From: Iqraa Malik
Sent: 07 August 2020 08:12
To: Sian Eggington
Subject: FW: Request for further information FG/85/20/HH

Subject: Re: Request for further information FG/85/20/HH

BLOCK PLAN 1:500 @ A4
PROPOSED OUTBUILDING

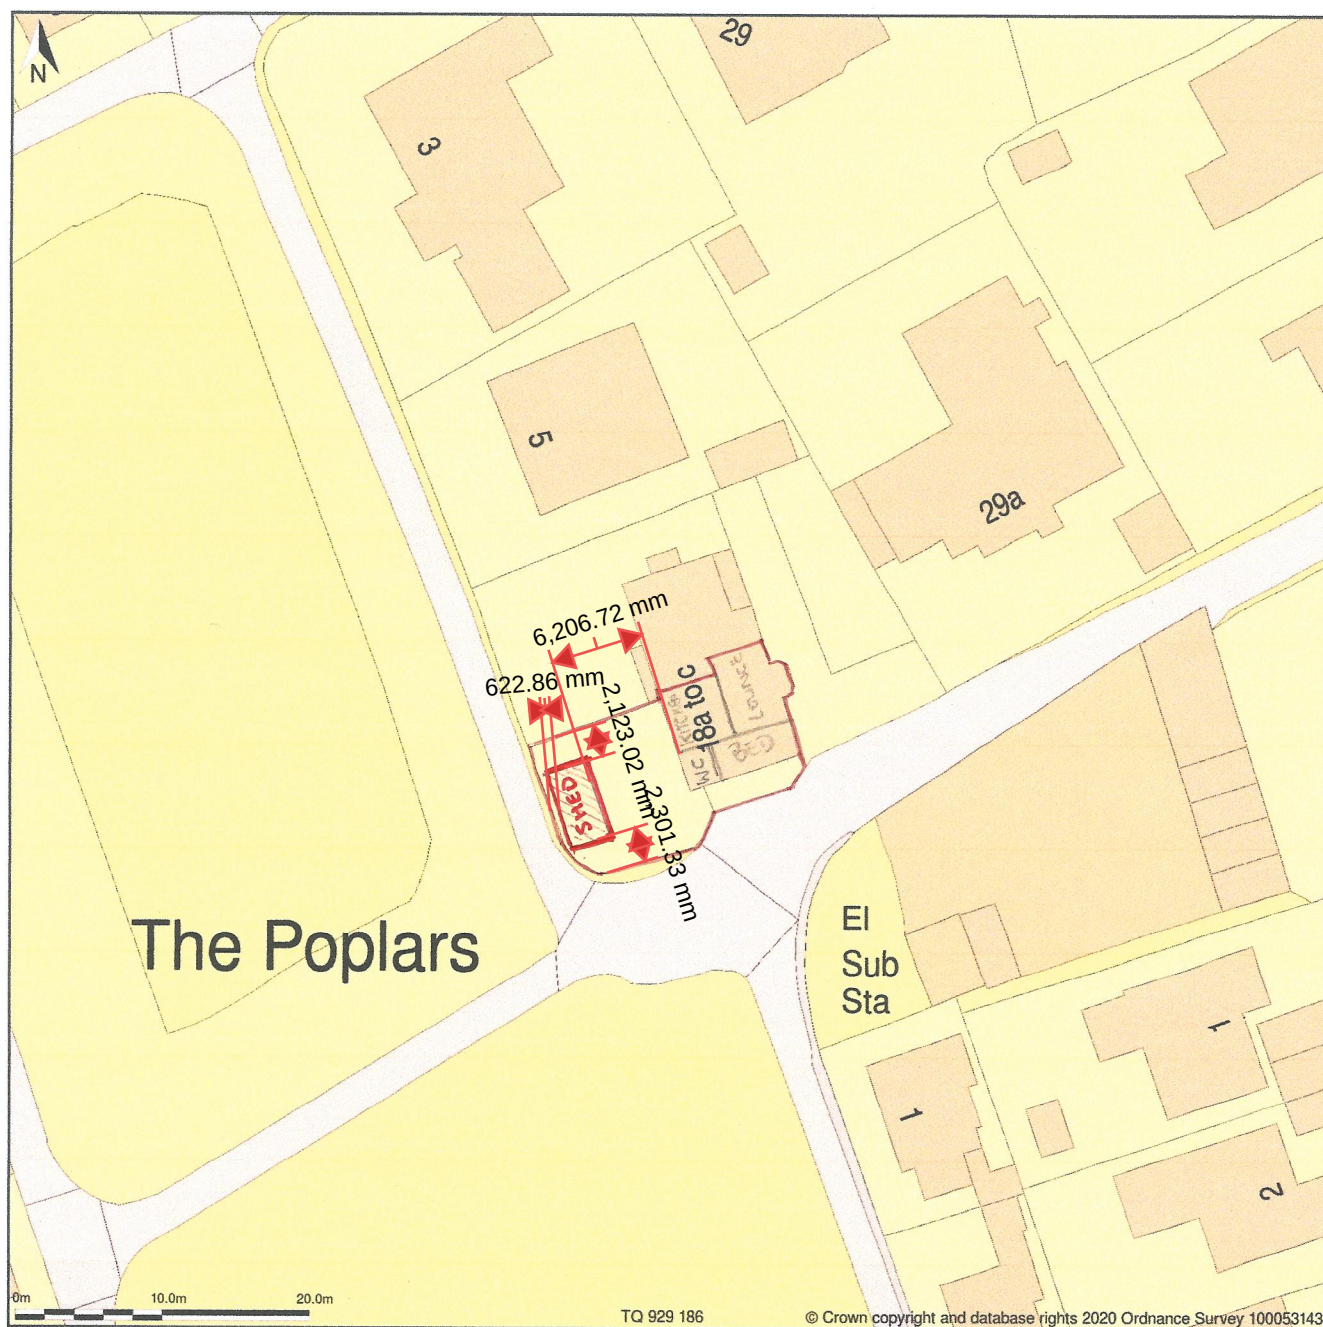
Please can you amend the block plan, if you need any more information then please let me know.

Unfortunately your application is still invalid as you require dimensions on your block plan from the proposed extension to all site boundaries. Please amend or with your permission, we are able to amend this for you.

The block plan was purchased online and has a scale of 1:500. The proposal is for a shed so the floor plan is just labelled 'shed'.
